GEOSCAPES Reference: # 210611_SSD_LET_RTC01

Re. ARDEX Warehouse and Manufacturing Facility (SSD-25725029) – Response to DPIE comments

LANDSCAPE CONCEPT PLAN 02

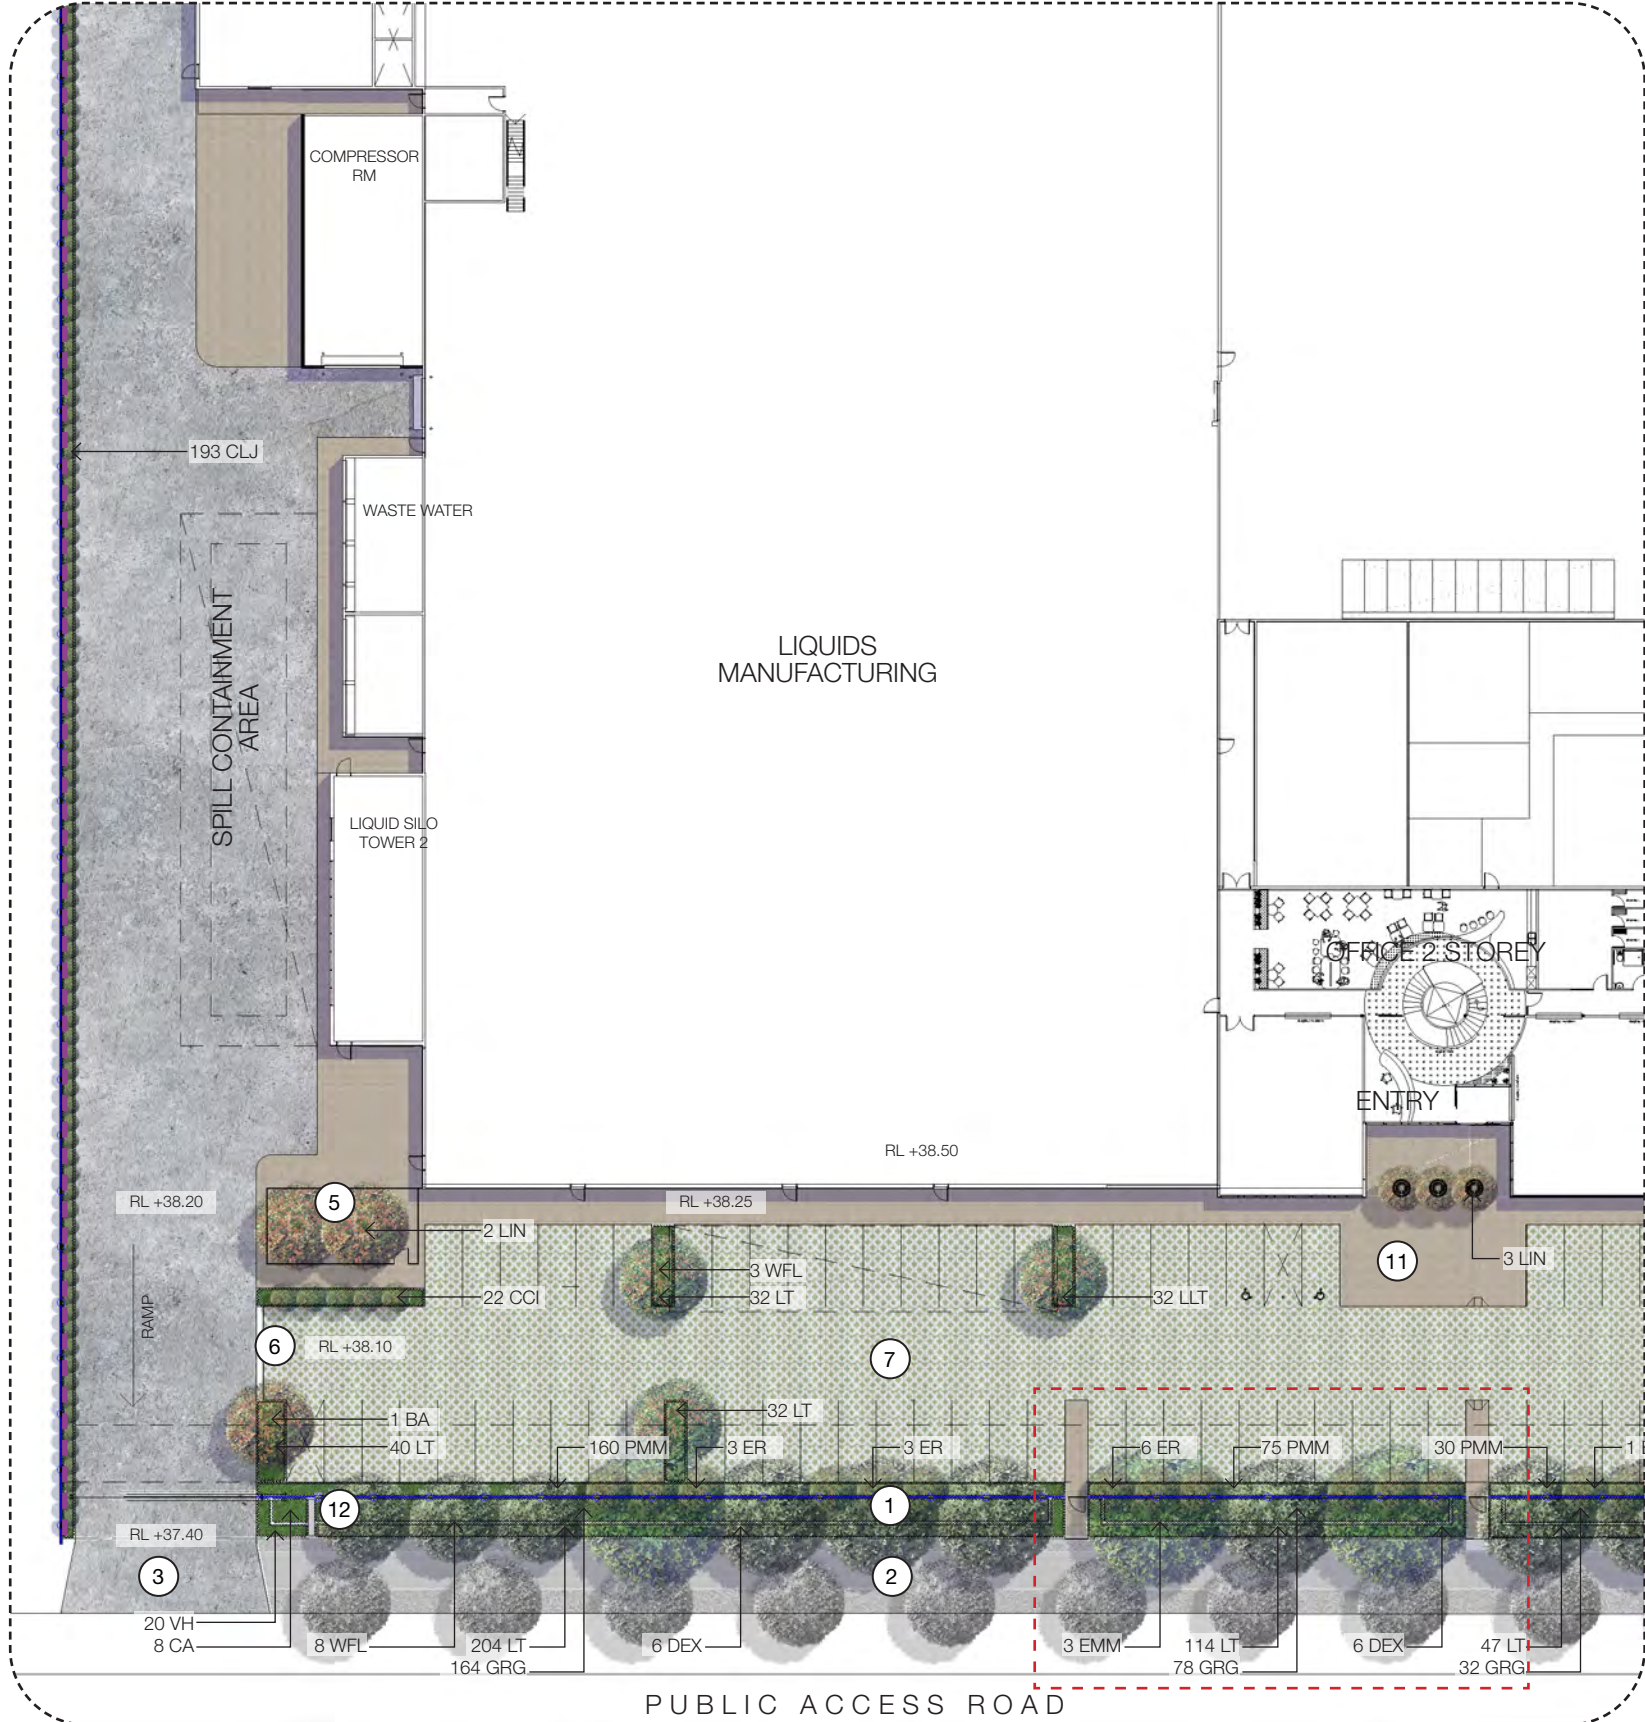
16. 'The VIA relies on vegetation plantings to screen the proposal. Please confirm on a plan which landscaping is approved under SSD-9522, which is proposed as part of this development and what landscaping is outside of the subject site.'

The vegetation and screening shown within the photomontages is described within Sections 2.8 & 2.9 with a tabulated breakdown including other approved or future developments. All proposed landscape design has been incorporated for each development listed in the VIA and adjusted to suit the relevant timeframe of each image. This was achieved by referring to landscape documentation produced by Habit8. Ardex landscape drawings are included in Section 7.0 of the VIA, however, all other plans were sourced from and available in their respective applications (SSD-9522 MOD 1 and SSD-10101987), these too were produced by Habit8.
